Recommendation Report for Planning Permission

REF NO: F/2/20/PL

LOCATION: Land Adjacent Station Cottages
Ford Road
Ford
BN18 0BH

PROPOSAL: Change the use of 1/2 the site area to a hard standing storage area (resubmission following F/9/19/PL).

Proposed Fence and earth mound elevation

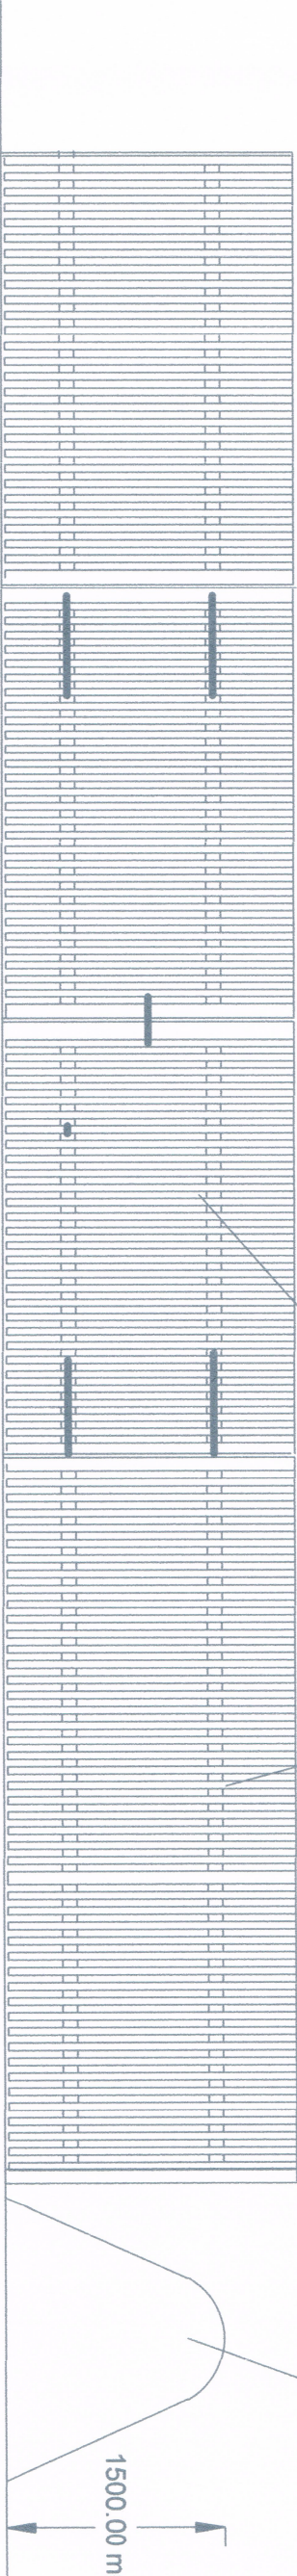
The 2 metre metal palisade fence and associated soil bund on the western boundary would remove the existing hedgerows and have an industrial and alien appearance within the countryside landscape.

Proposed entrance and hard standing
alteration with change of use

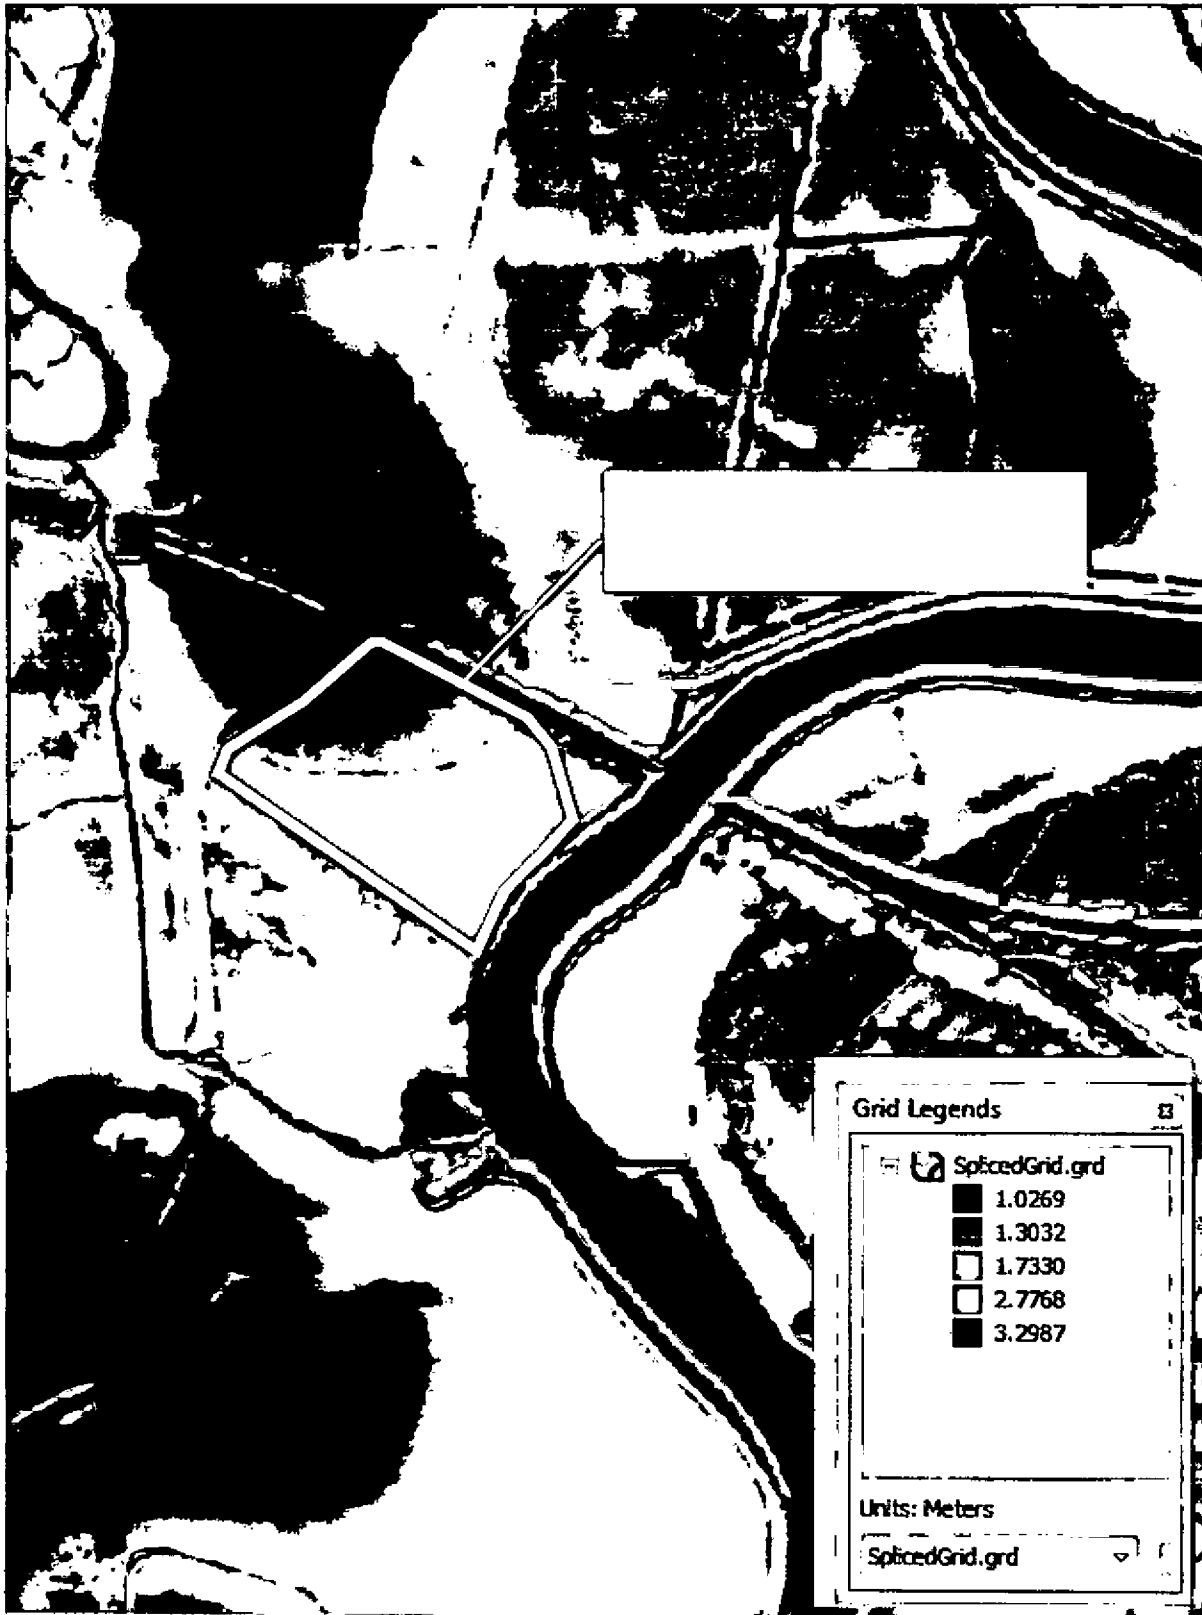
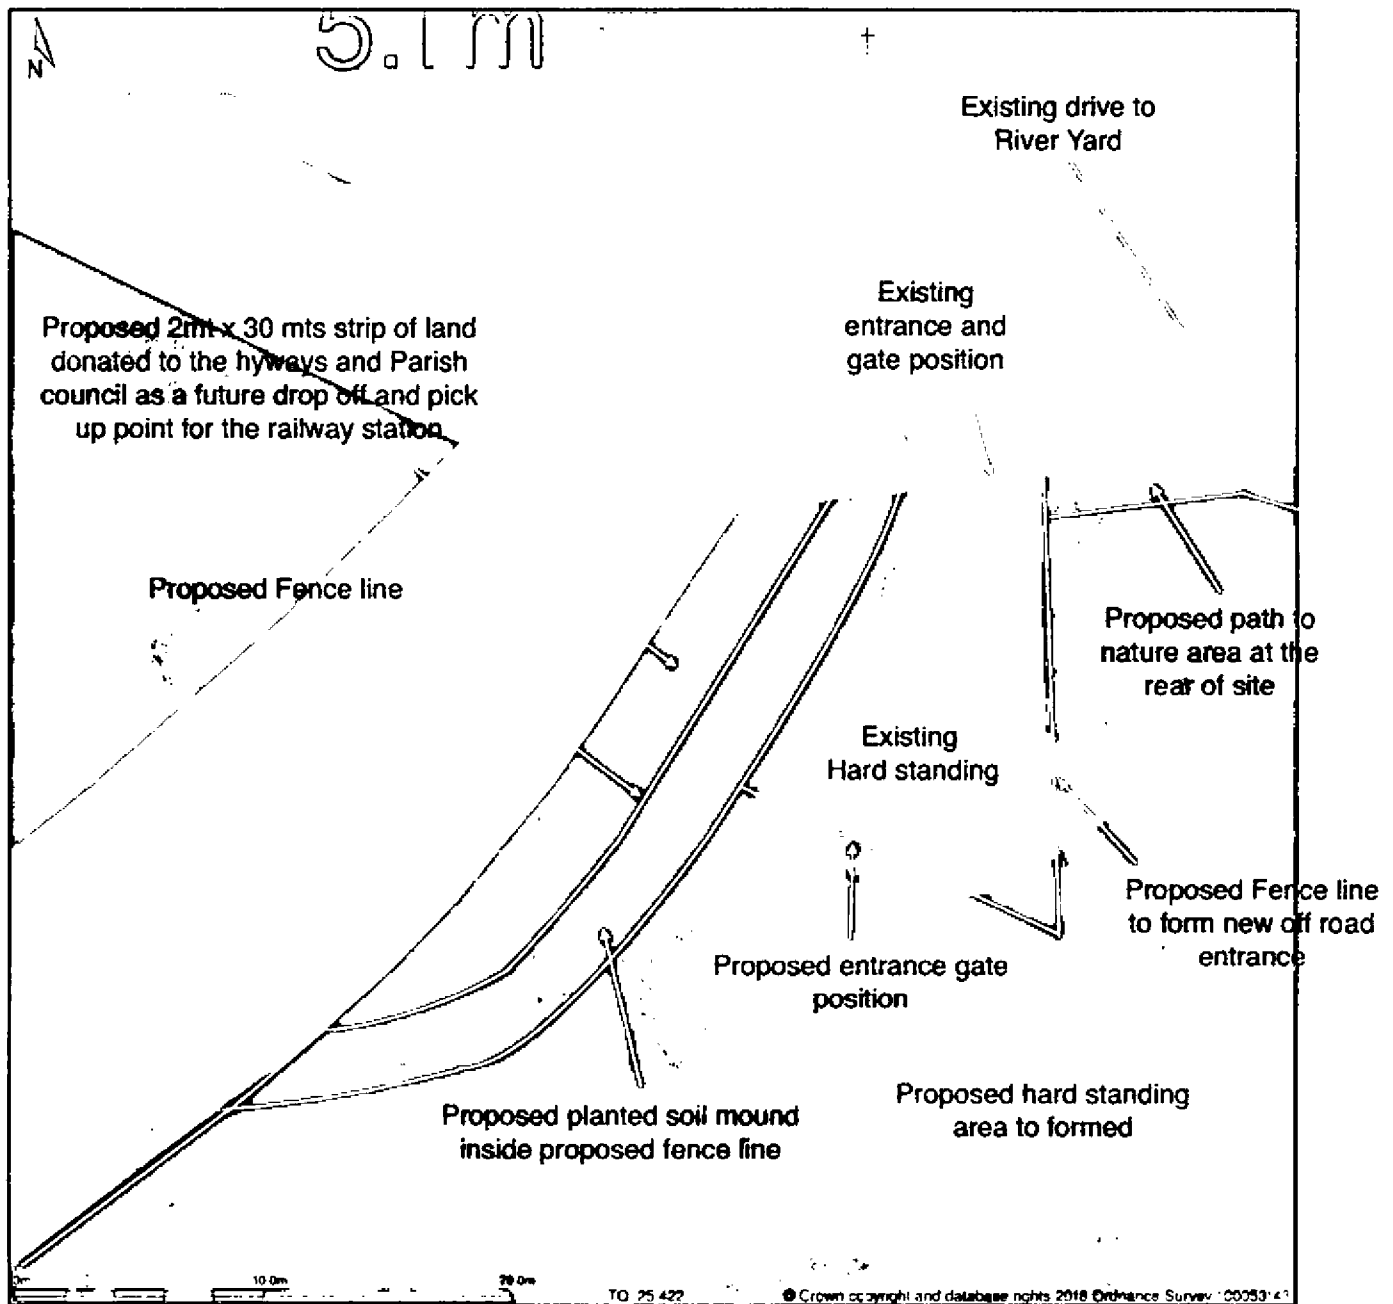
The site slopes down towards the river and would face toward the public footpath that is the Littlehampton to Arundel Green Link. The proposed border landscaping would fail to screen the development when viewed from this public access vantage point and the wider landscape to the south and east representing poor landscape management practice in conflict with policy TSP2 of the Arun Local Plan. The block plan proposes a nature and wetland area for public use but provides no details of it to demonstrate how it would ameliorate any impact on views of the Littlehampton to Arundel Green Link.

The proposal would due to its height, mass and scale, result in substantial harm to the rural character of the locality and wider landscape and the Littlehampton to Arundel Green Link. The proposed landscaping would not provide a sufficient screening of the site from open views across the wider landscape particularly in winter months. The proposal would be contrary to ALP policies D DM1, D SP1, T SP2, LAN DM1 & Policy EH1 of the Ford Neighborhood Plan.
